### **Project# 1009438**

14DRB-70019 – PRELIMINARY/ FINAL PLAT APPROVAL

CONSENSUS PLANNING agents for RPS I-25 & VASSAR LLC, ET. AL. request the referenced/ above actions for all or a portion of Tracts A-C, **AVALON SUBDIVISION UNIT 4**; Tracts 4-7, **TOWN OF ATRISCO GRANT**; Tracts B-11 thru B-13, B-22 thru B-27, and B-29 thru B-33, **TOWN OF ATRISCO GRANT UNIT 5**, Tract B-14A, **UNSER DIVERSION CHANNEL CORRIDOR**; Tract C, **WESTRIDGE MOBILE HOME PARK PHASE 2**; and Tracts 14-16, **LAND OF C.H. HALL** zoned SU-1/ IP and SU-1 FOR IP & C-2 WITH EXCEPTIONS, located on the south side of I-40 between 90TH ST NW and 98TH ST NW containing approximately 172.4503 acres. (J-9 & K-9)

**RE: Proposed Avalon Subdivision Unit 5**

FINAL TRACTS - SHEET 2

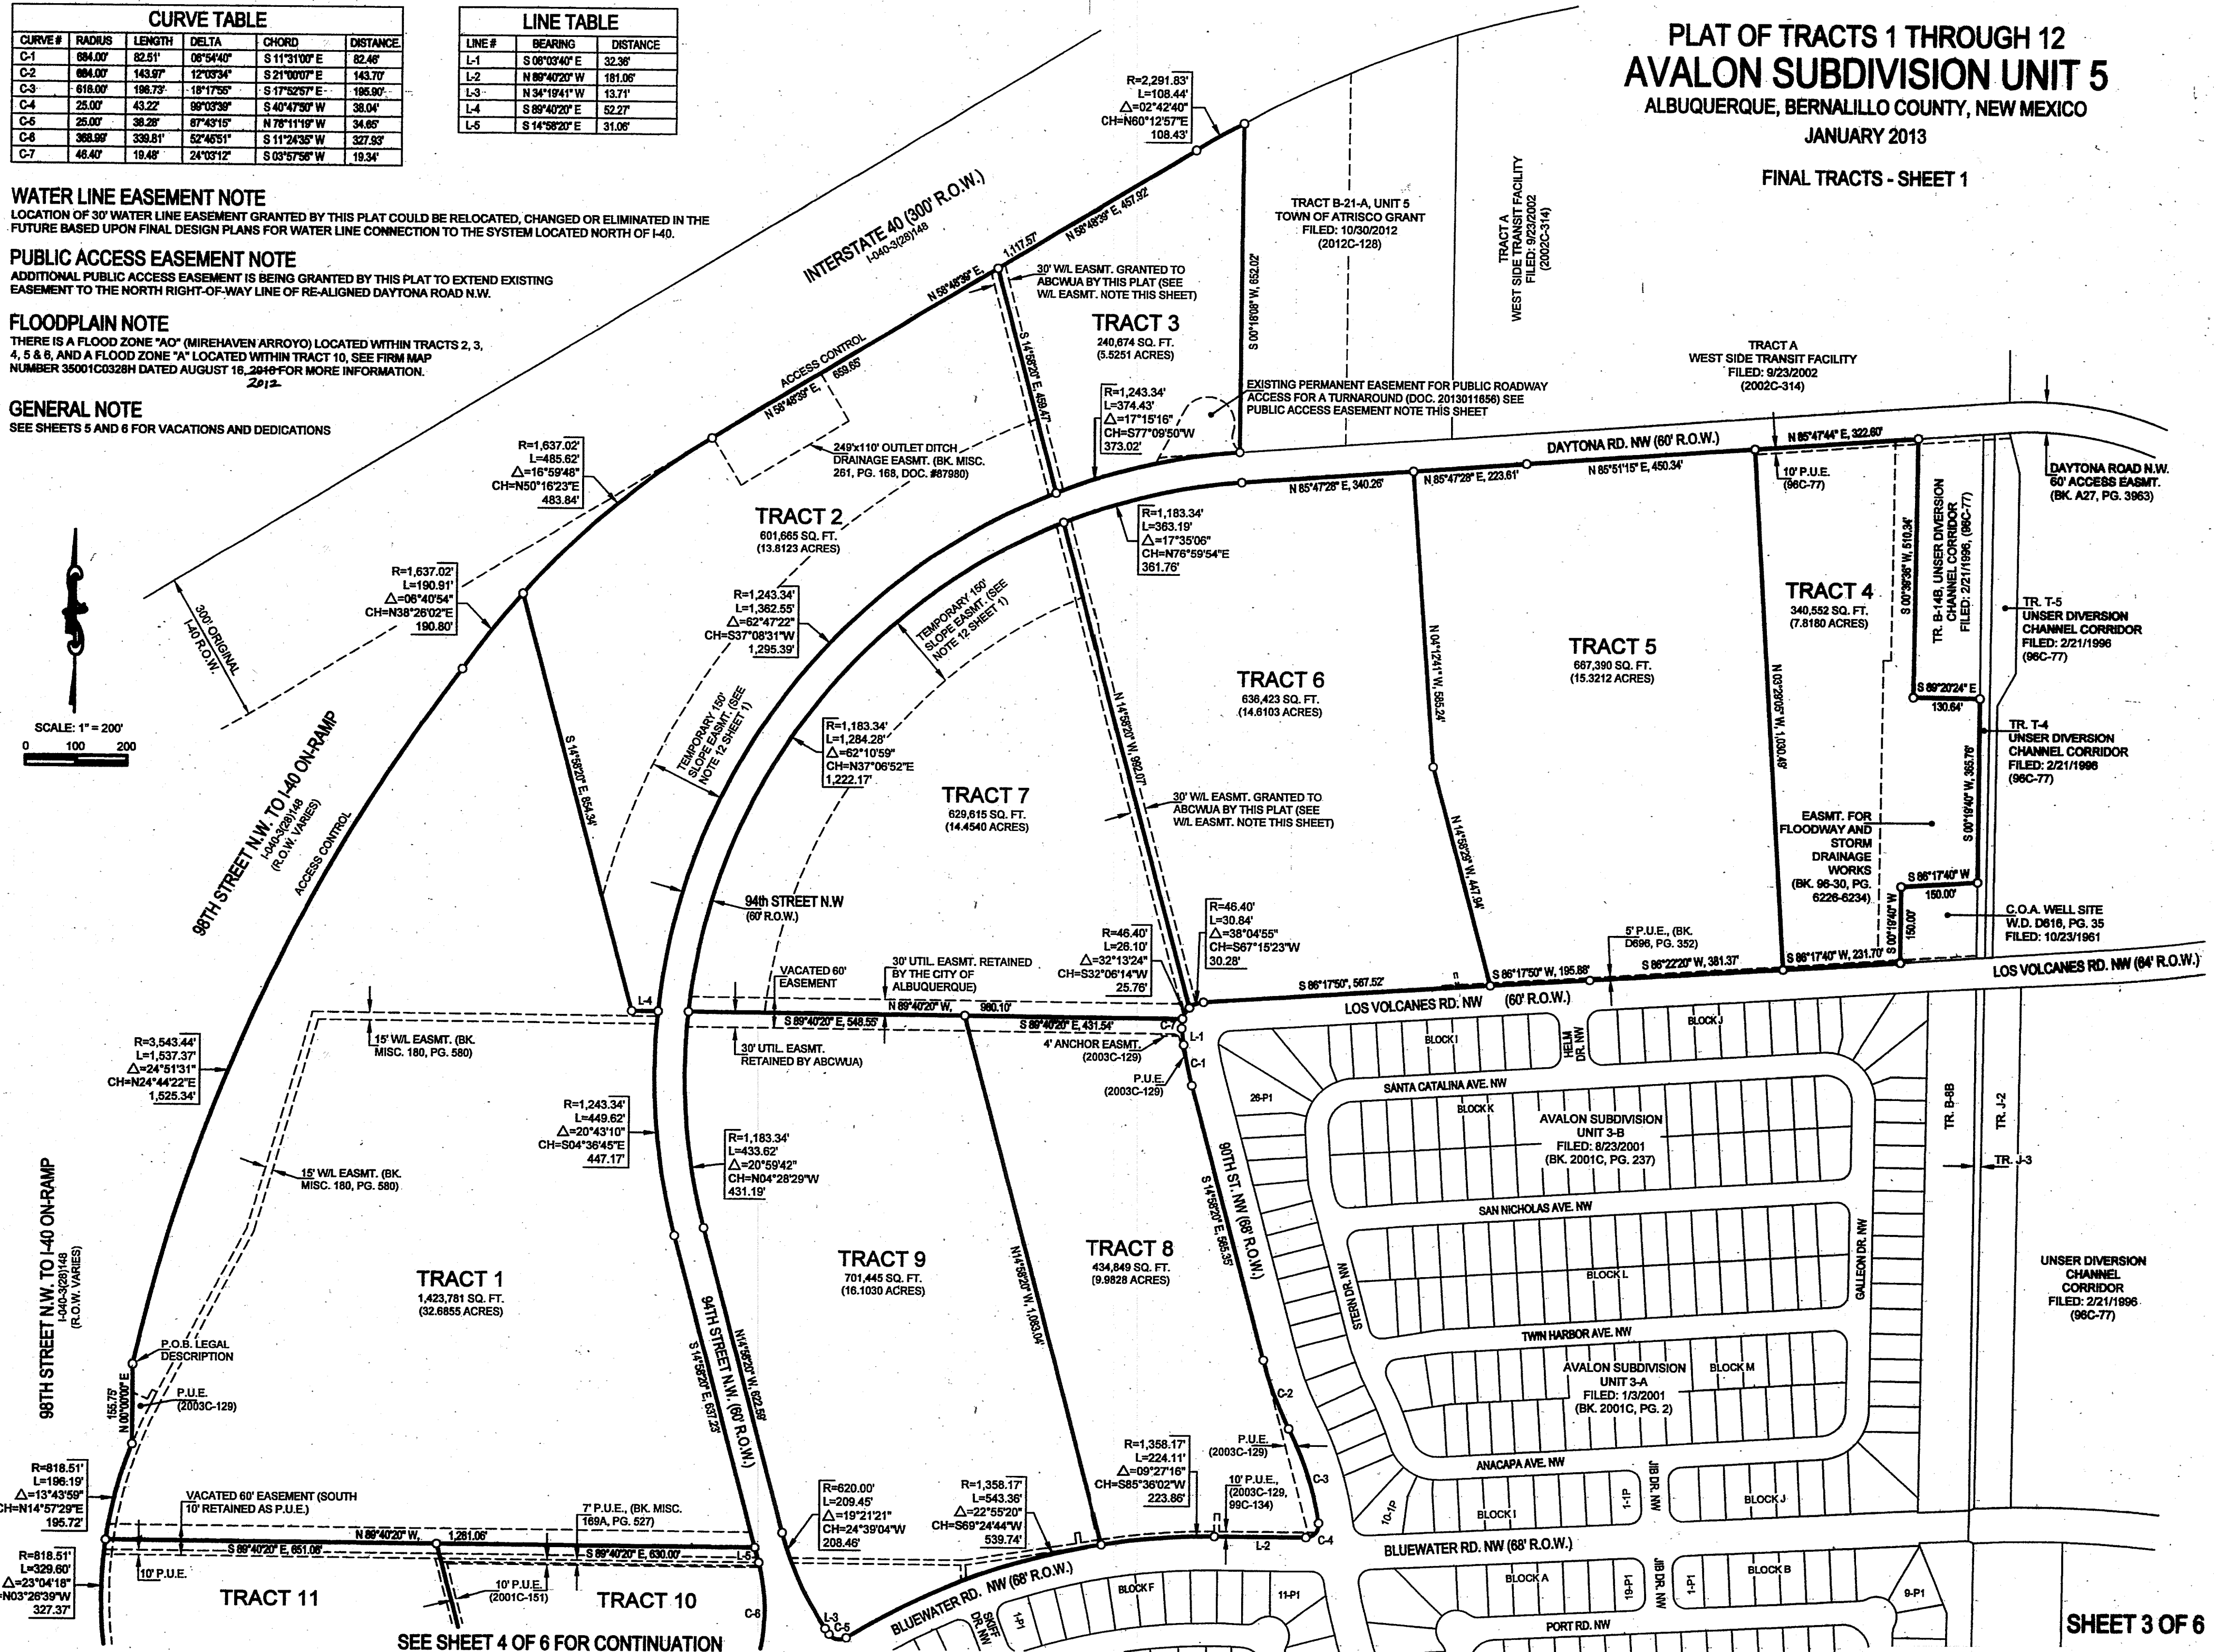
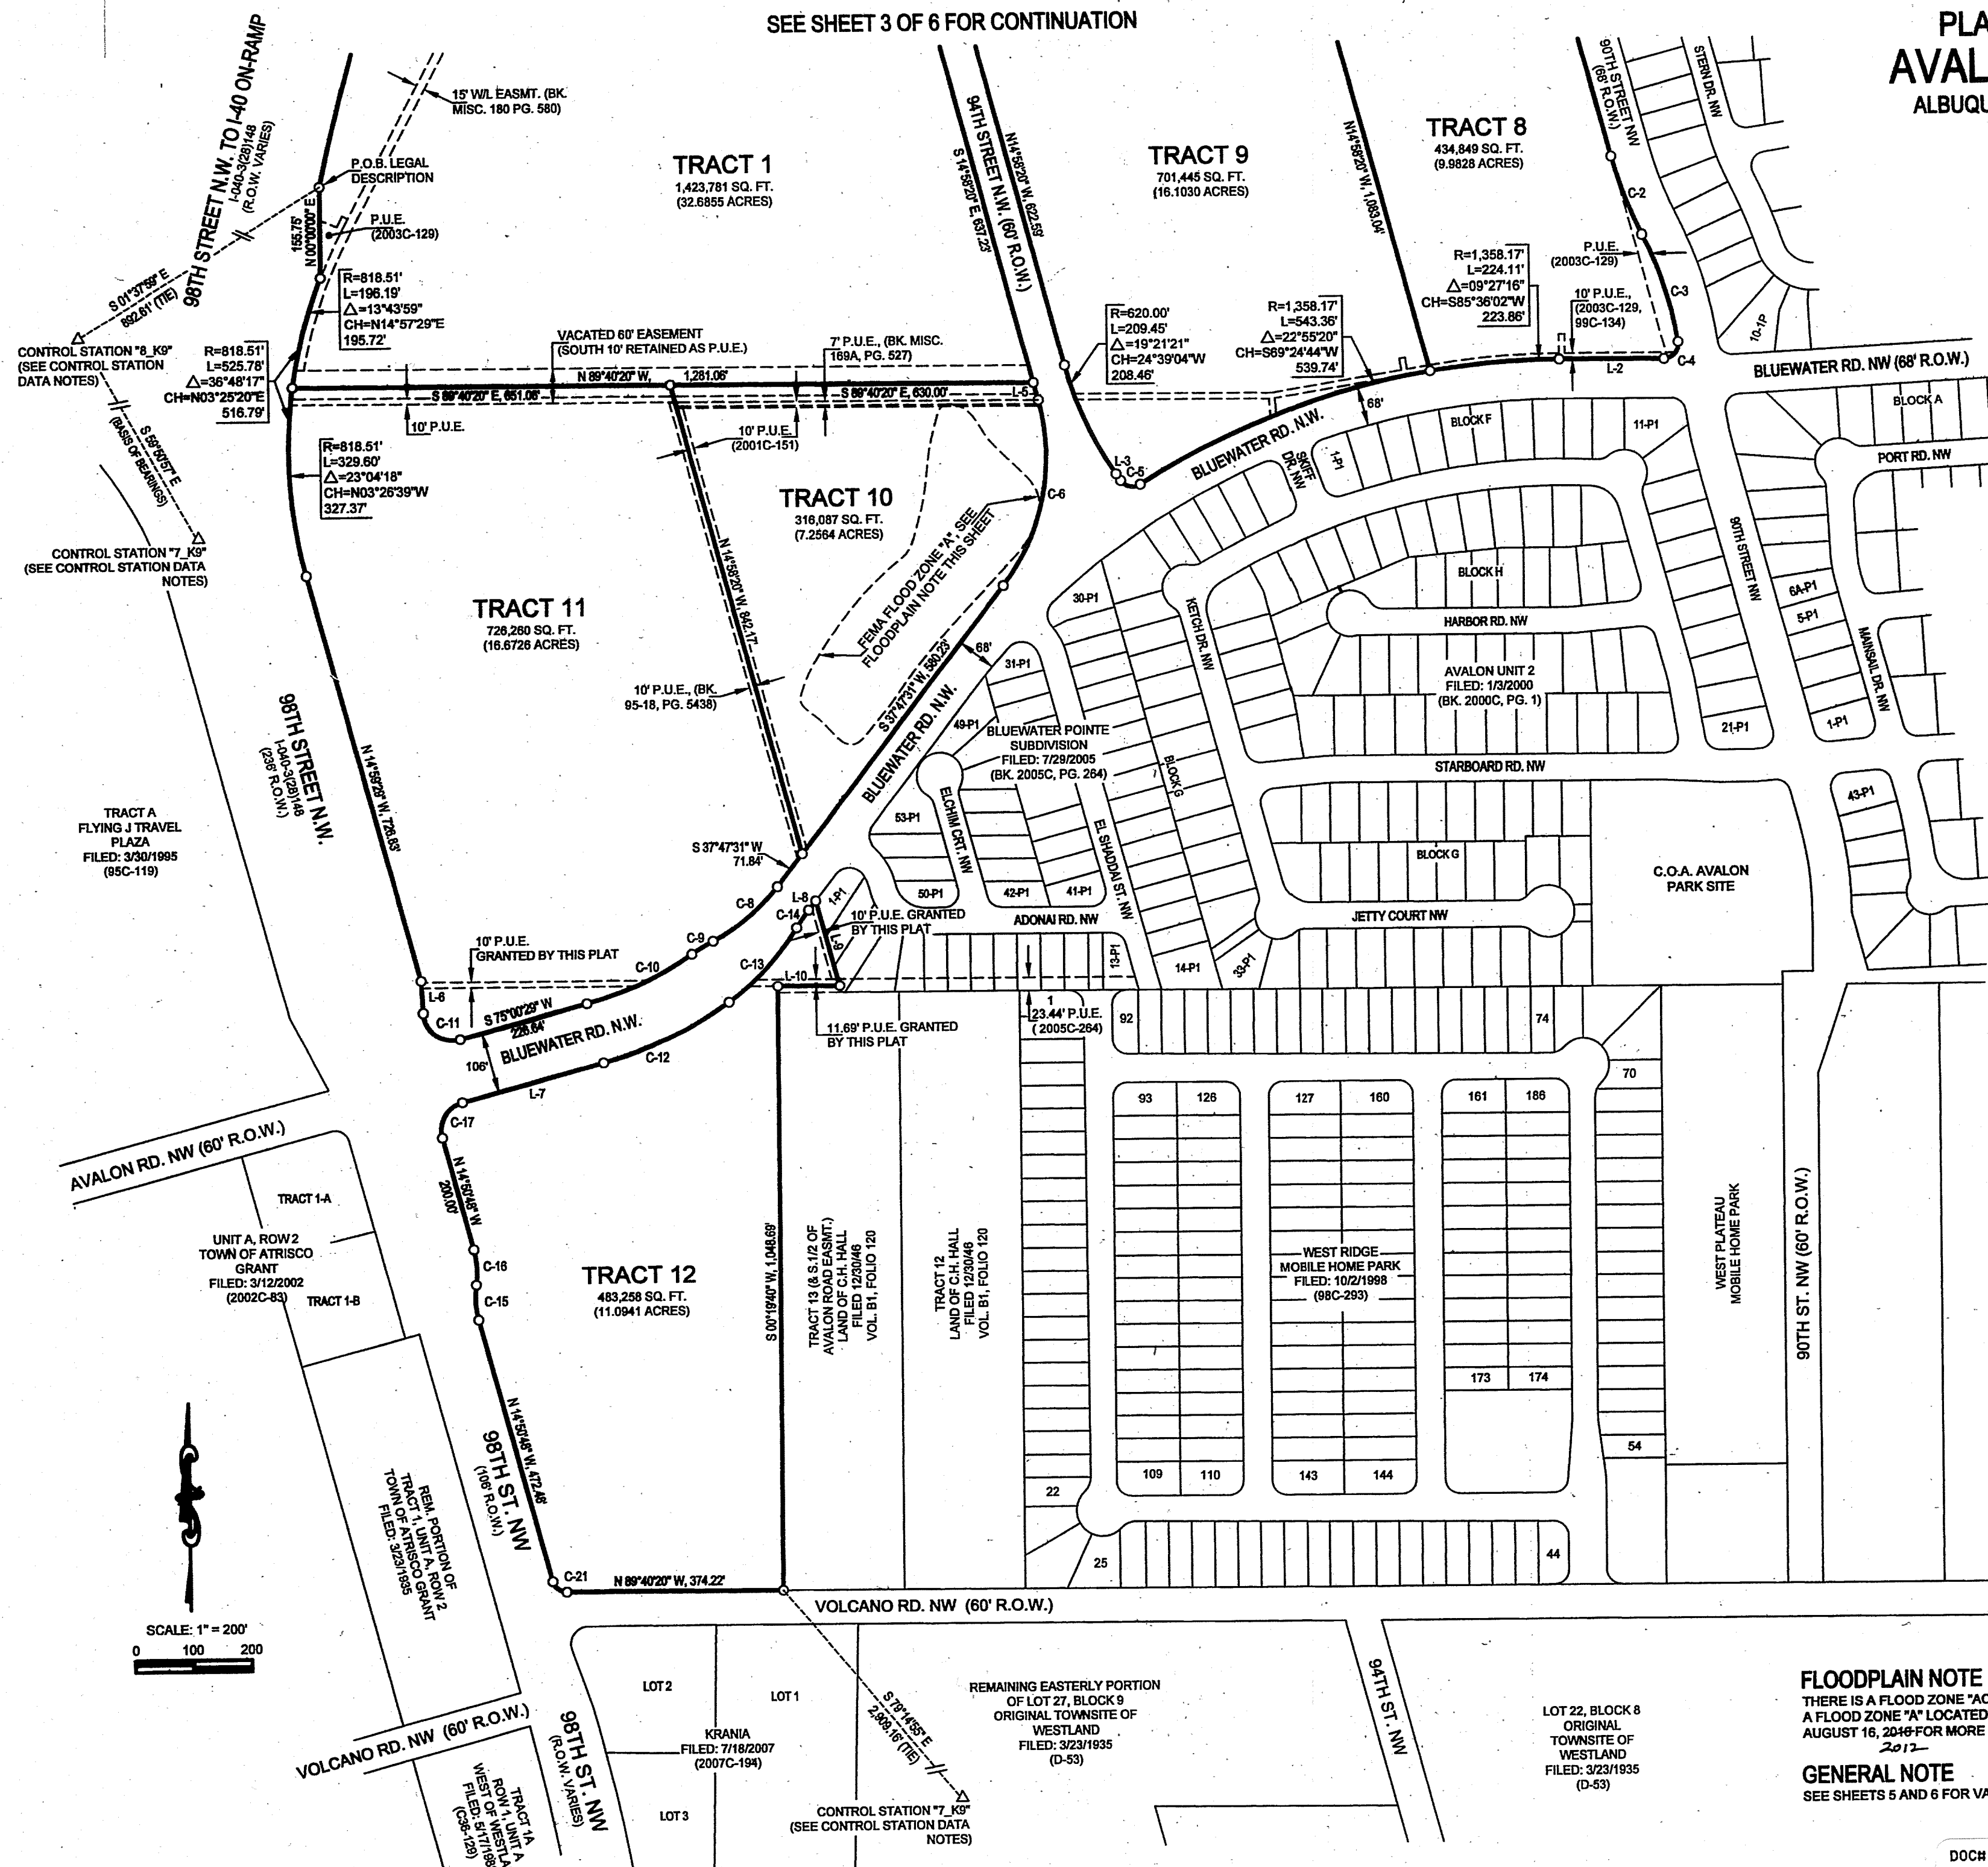
1. AMAFCA cannot approve vacation of the AMAFCA Floodplain Easement (99C-31) until the AMAFCA Board of Directors approves the Quitclaim Deed for the easement.
2. The grant of easement designation for the Mirehaven Arroyo will be changed to “Temporary Floodplain Easement,” and AMAFCA’s standard dedication language will be added.
3. The easement width will be at least 5 feet beyond the existing FEMA floodplain limit on each side.
4. AMAFCA will sign the Final Plat.

<b>ABCWUA</b> <hr/> Replace "...encouraged to coordinate with the ABCWUA" with "...required to coordinate with the ABCWUA".
<b>PLANNING DEPARTMENT</b> Approval of this application must be deferred to be heard concurrent with or subsequent to the vacations required for the proposed plat. For the plat, please remove owners' names from Sheets 5 & 6 and remove hatching from underneath/ over printed information ("AREA", "R.O.W." ETC.). Refer to comments from affected agencies plus any public hearing comments regarding proposed Bulk Land Variance.
